ENG-SP20008-R3-PrelimPlan-redlines.pdf Markup Summary

522800030, 523300014
SKP 18-003 (Approved 2018)
RR-6 (NOT Correct)
RS-6000
Fall/Winter 2021
Single Family Residential
27.26 ac - 147 Lots (95%)

TRACT EXHIBIT

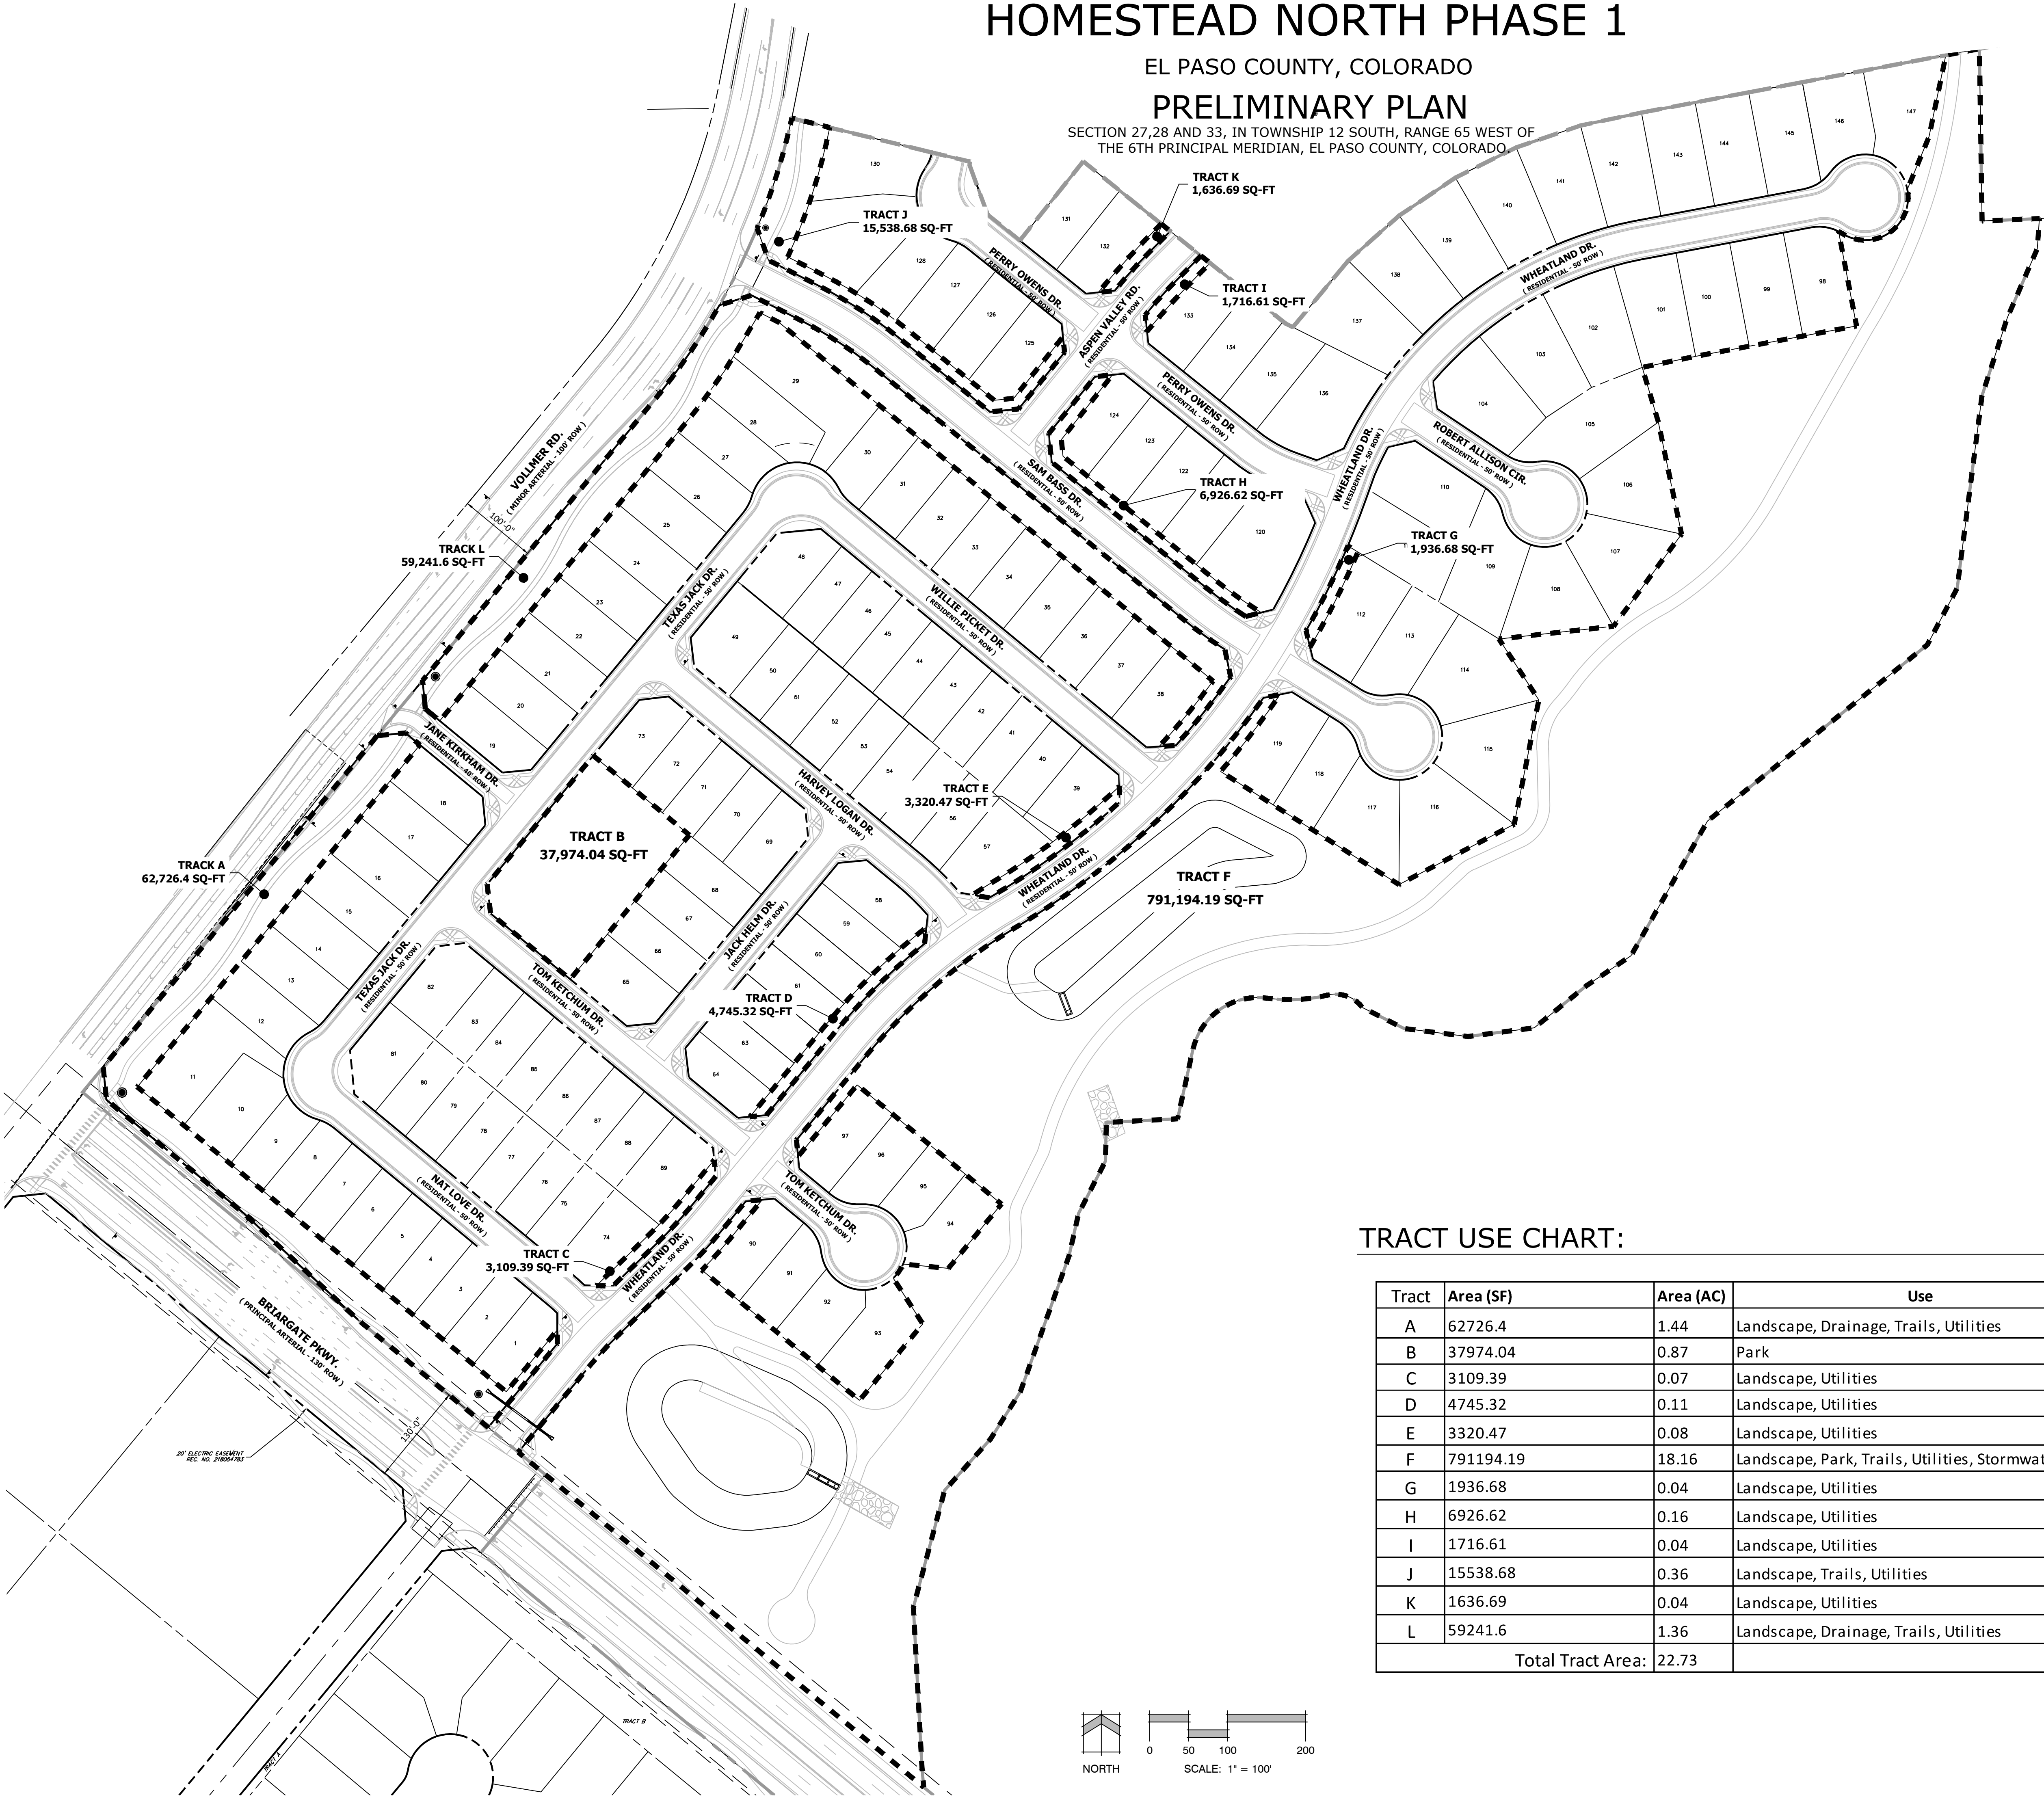
this is the tract exhibit (Add dimensions SF and acreage to all tracts;Subdivsion Boundary shall be depicted with distance and bearings

the previous review did have the information and it was removed with this review

label the maintenance trail width, surface (is this also a pedestrian trail?)

trail easement label //show throughout plan set

is there a trail connection to the regional trail from the development? Please show.

Briargate Prky and sterling ranch road are a part of the prelim plan boundary show heavy line consistent with prelim plan boundary (previously shown on submittal) and dimension and bearing it....centerline data is required on roads.

Is a continuous accel-decel lane being provided?

These lanes/transitions don't make sense. Show the ultimate road.

Show and label ROW dedication.

PRELIMINARY SITE PLAN

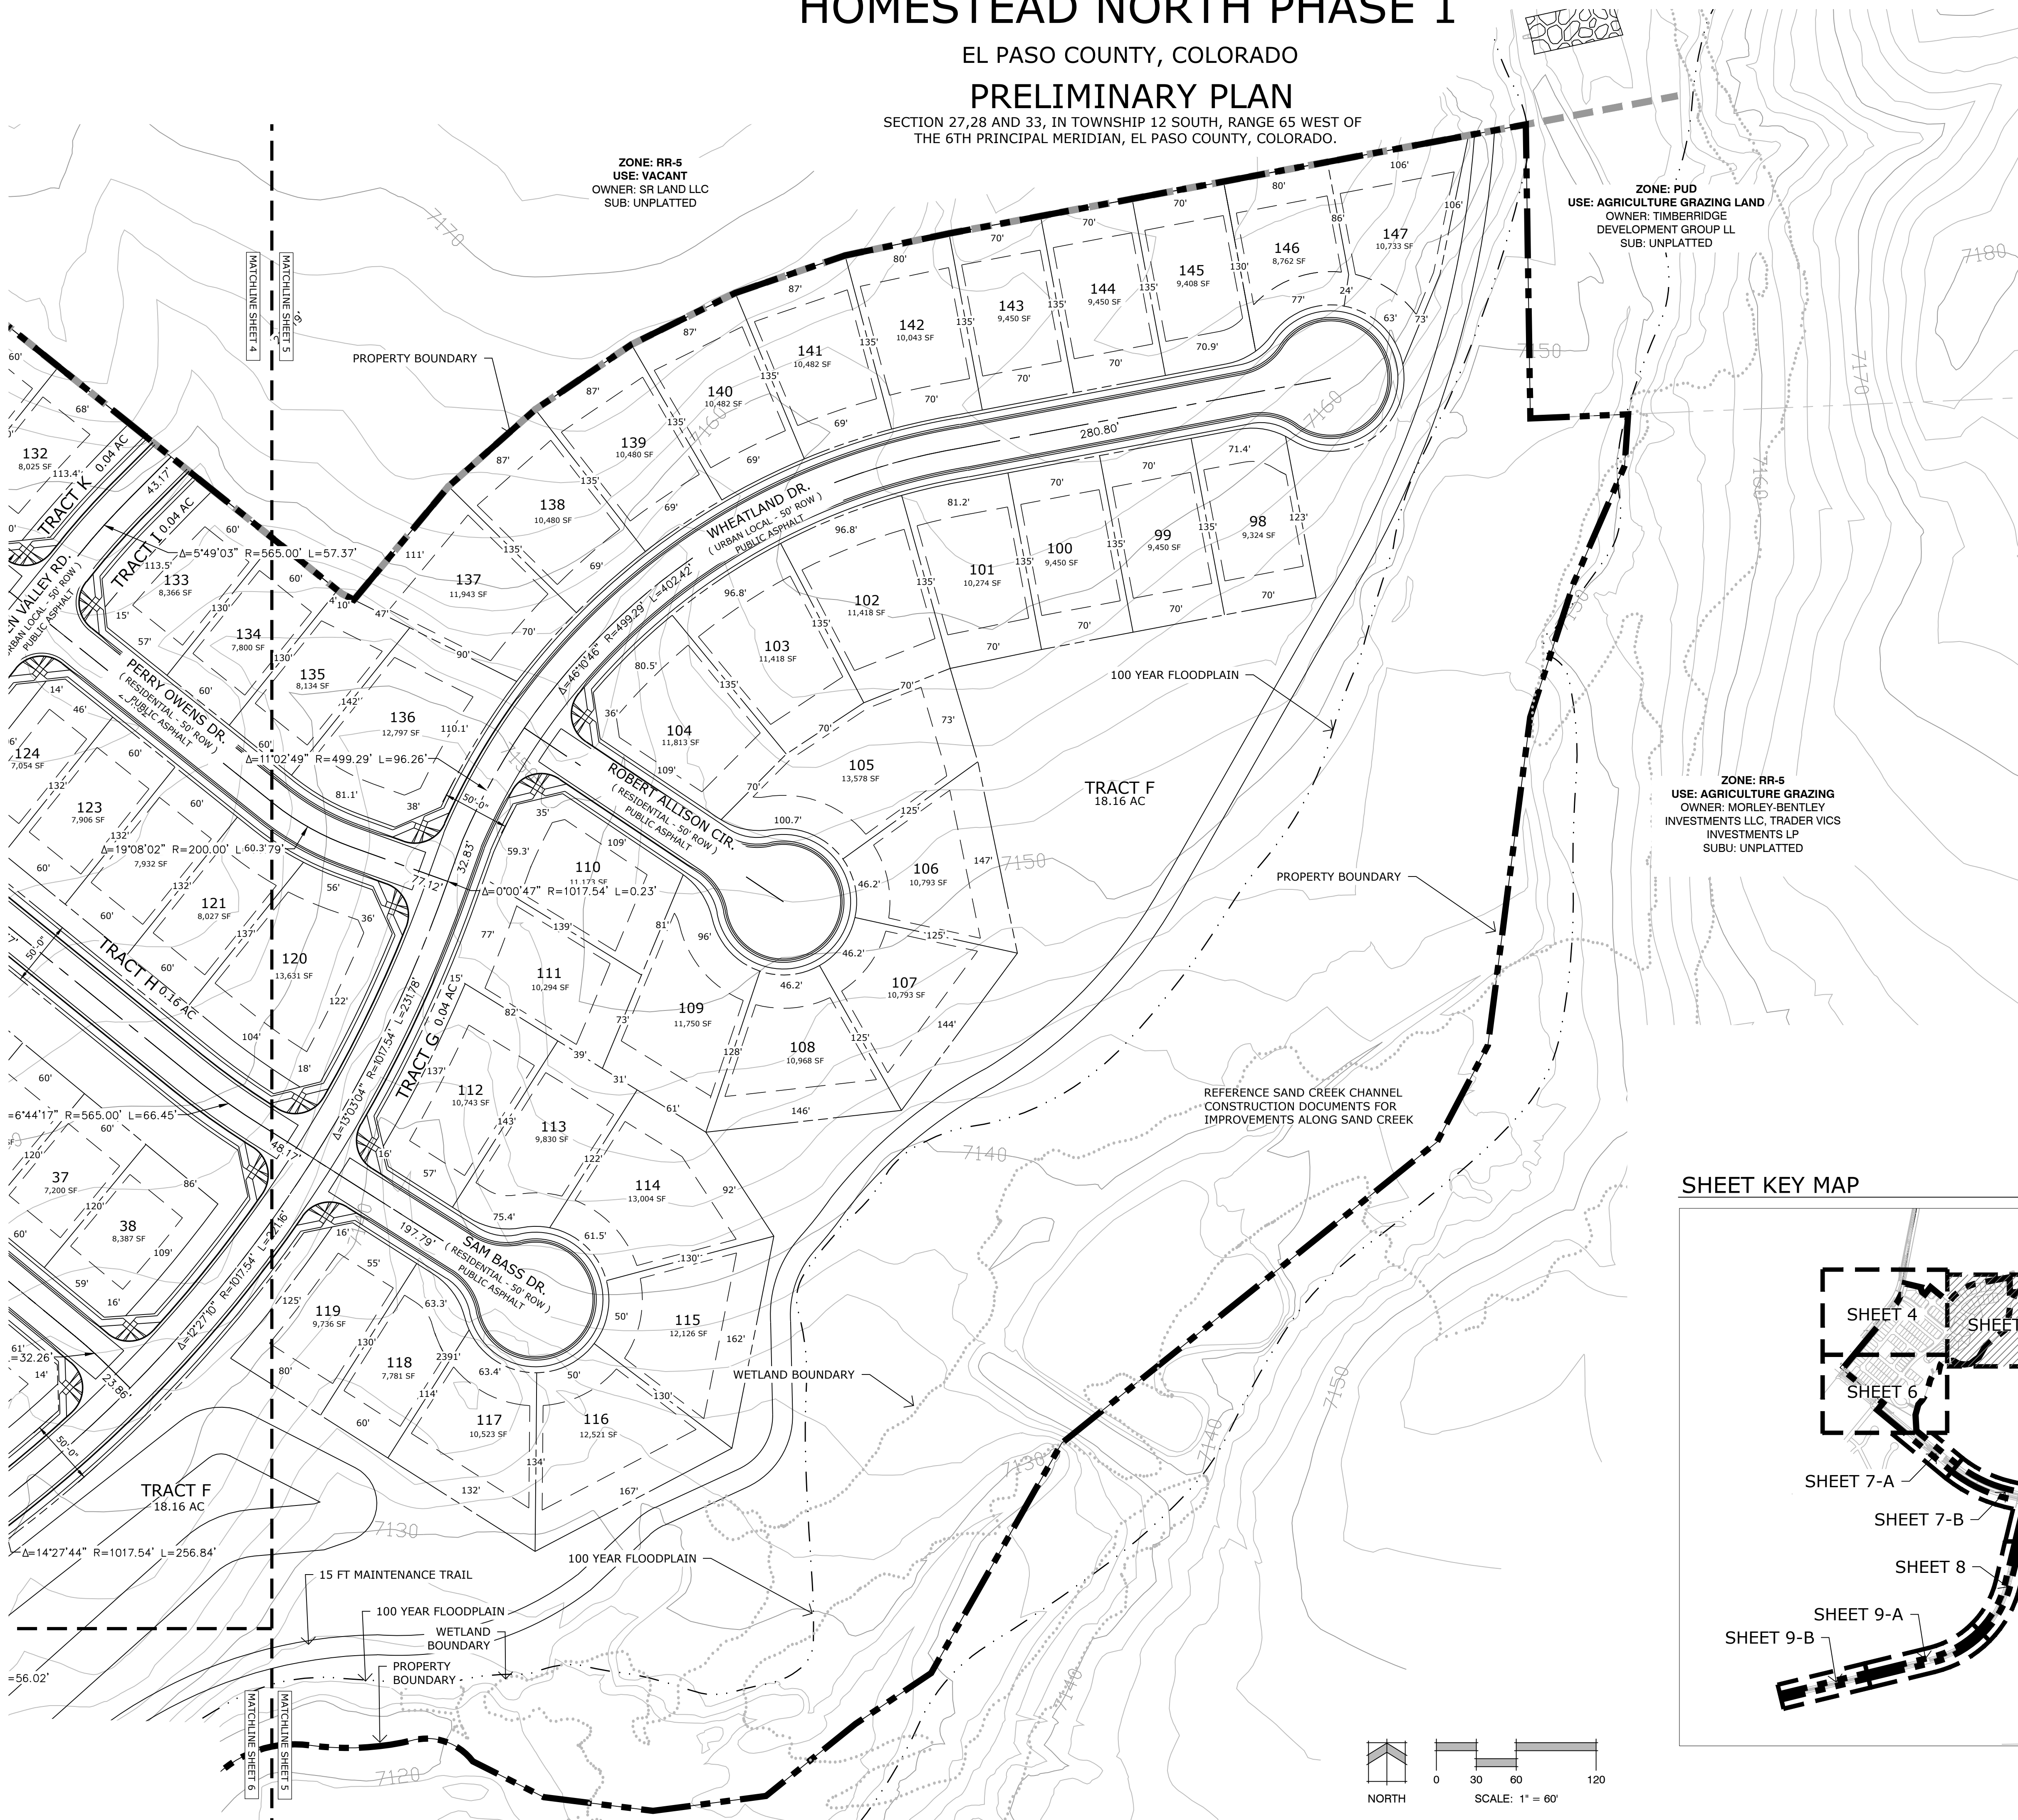
lot dimensions have been and are required all
prelim plan sheets/ tract dimensions are required

how do we check SF or acreage if dimensions are
not shown on tracts...

2:\Morley\SR Homestead Filling 3\Drawings\Planning\Develop\Homestead North Phase 1_PP.dwg [Sheet 6] 8/2/2021 8:42:45 AM biten

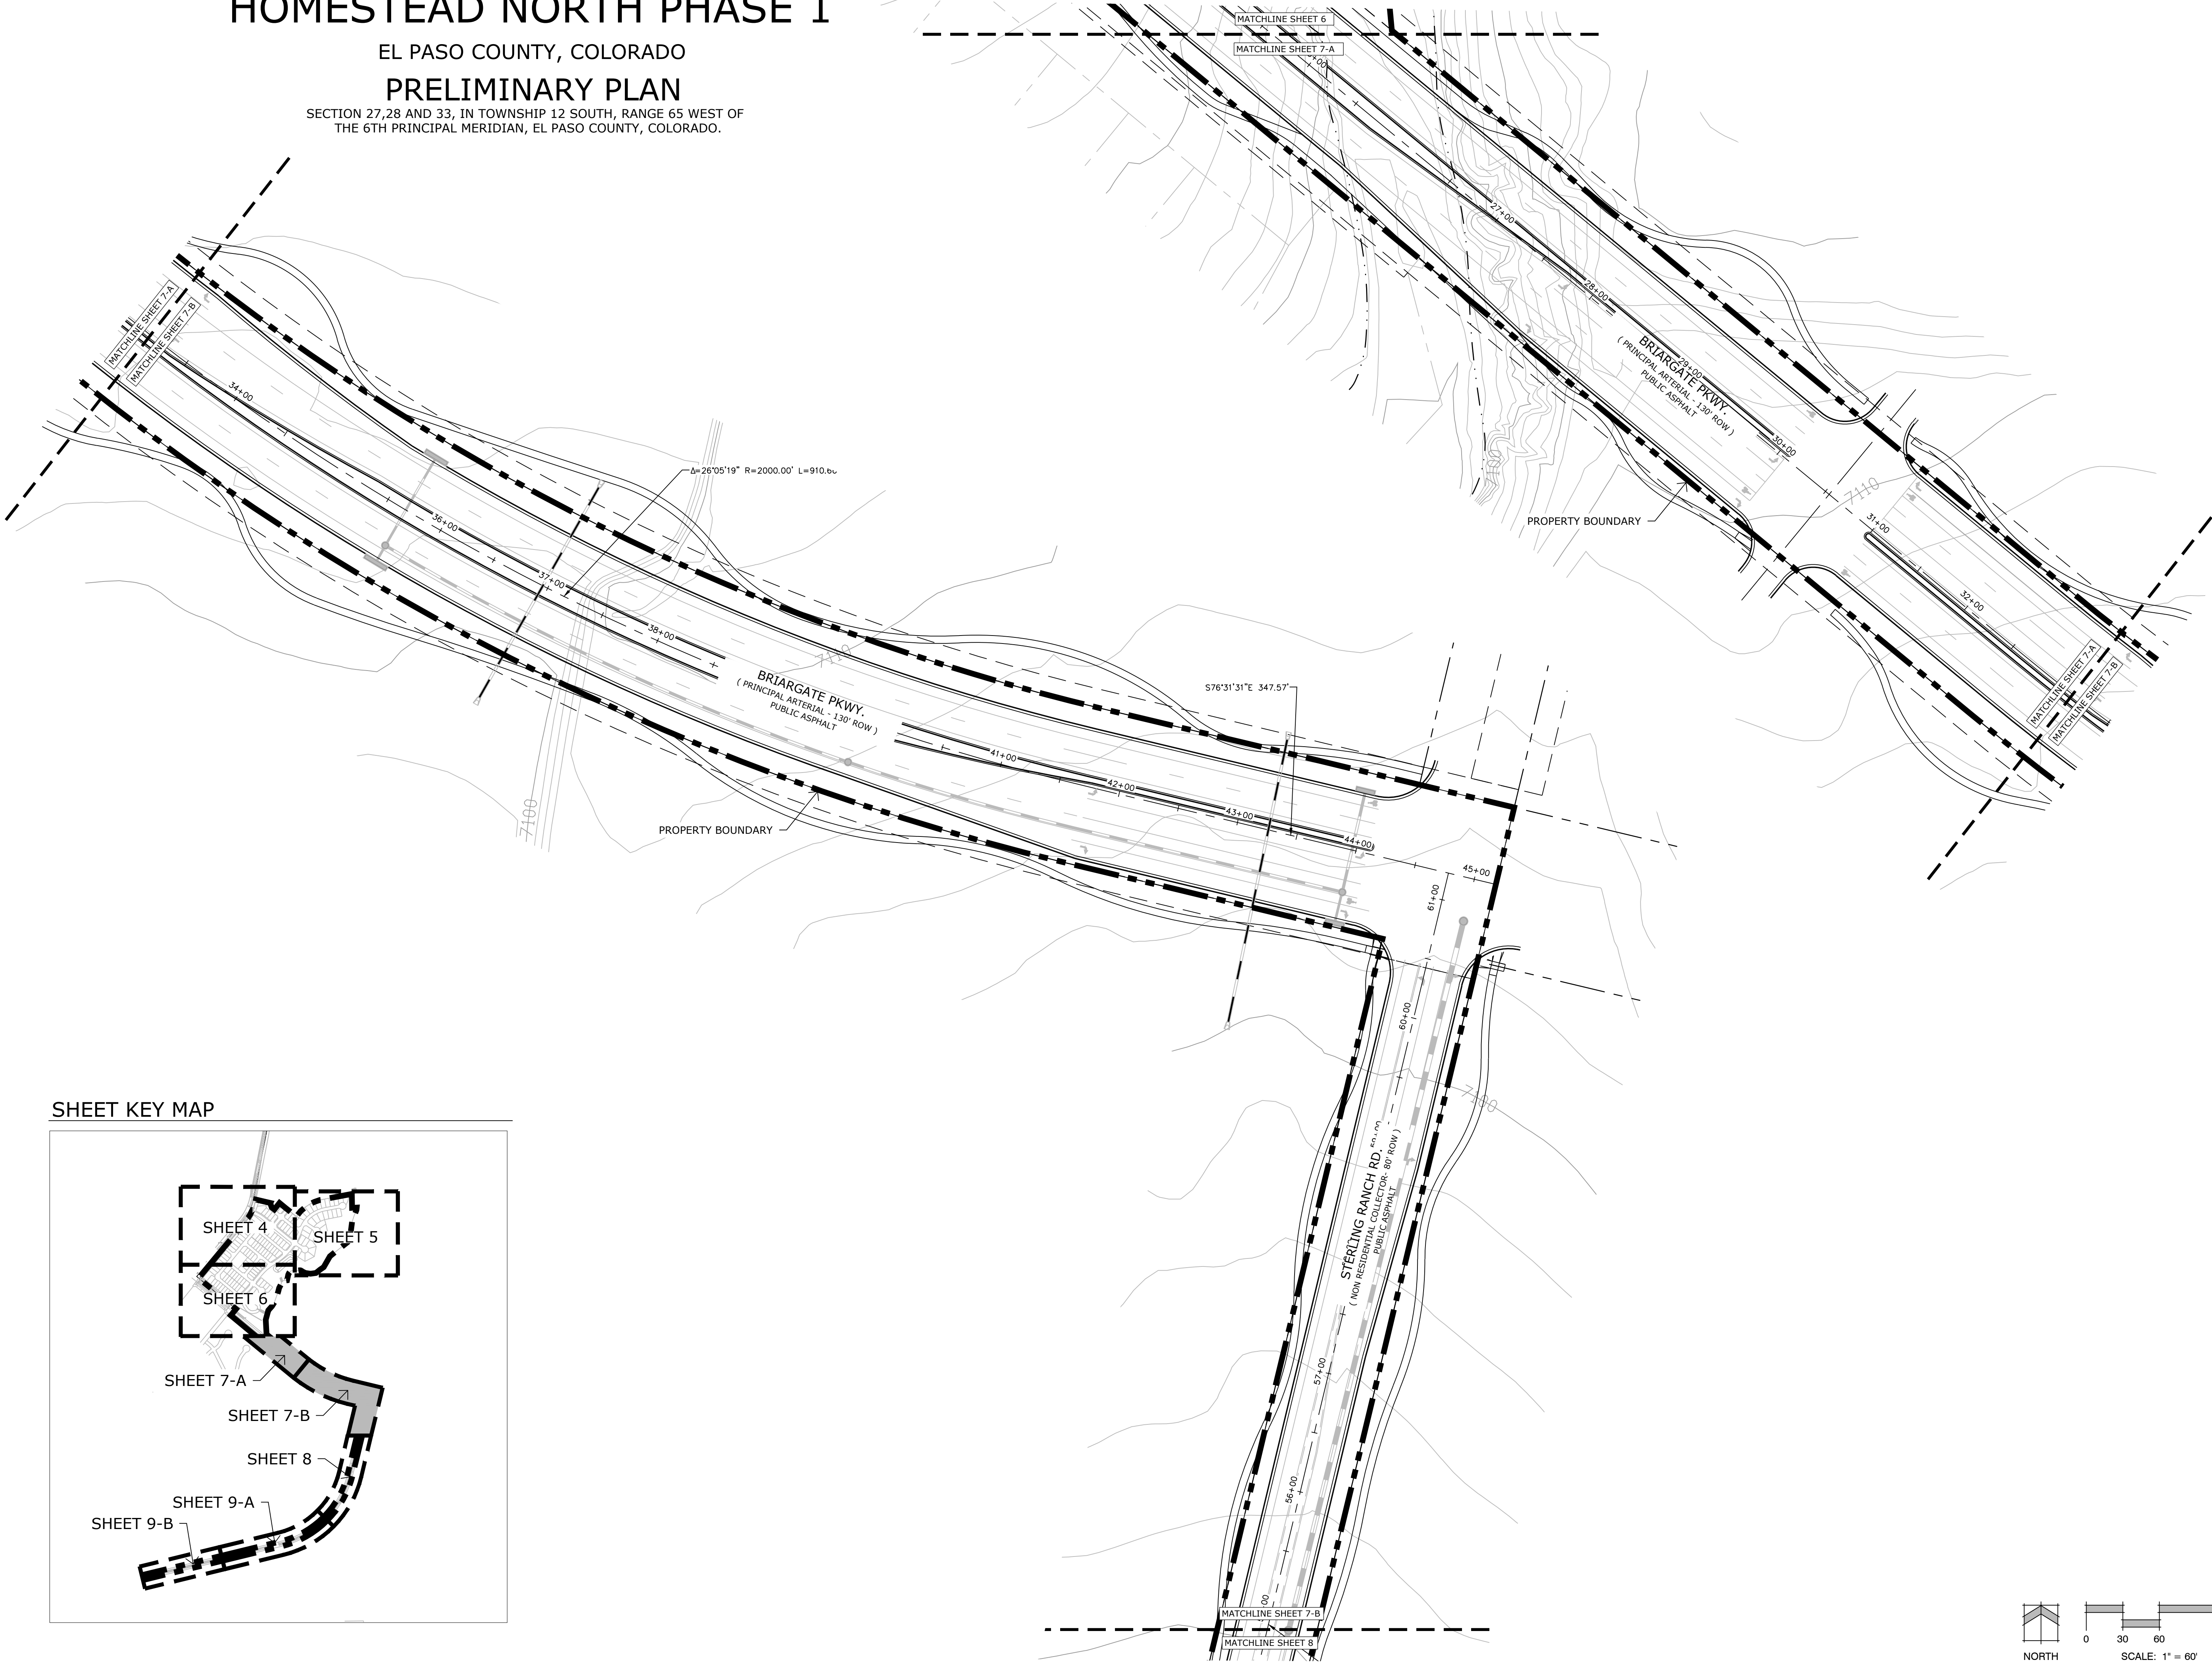
dimension

Provide all of the dimensions as redlined

Adjust text to show dimensions

Show conceptual channel improvements (can be grayed back) and 15' maintenance access roads on each side
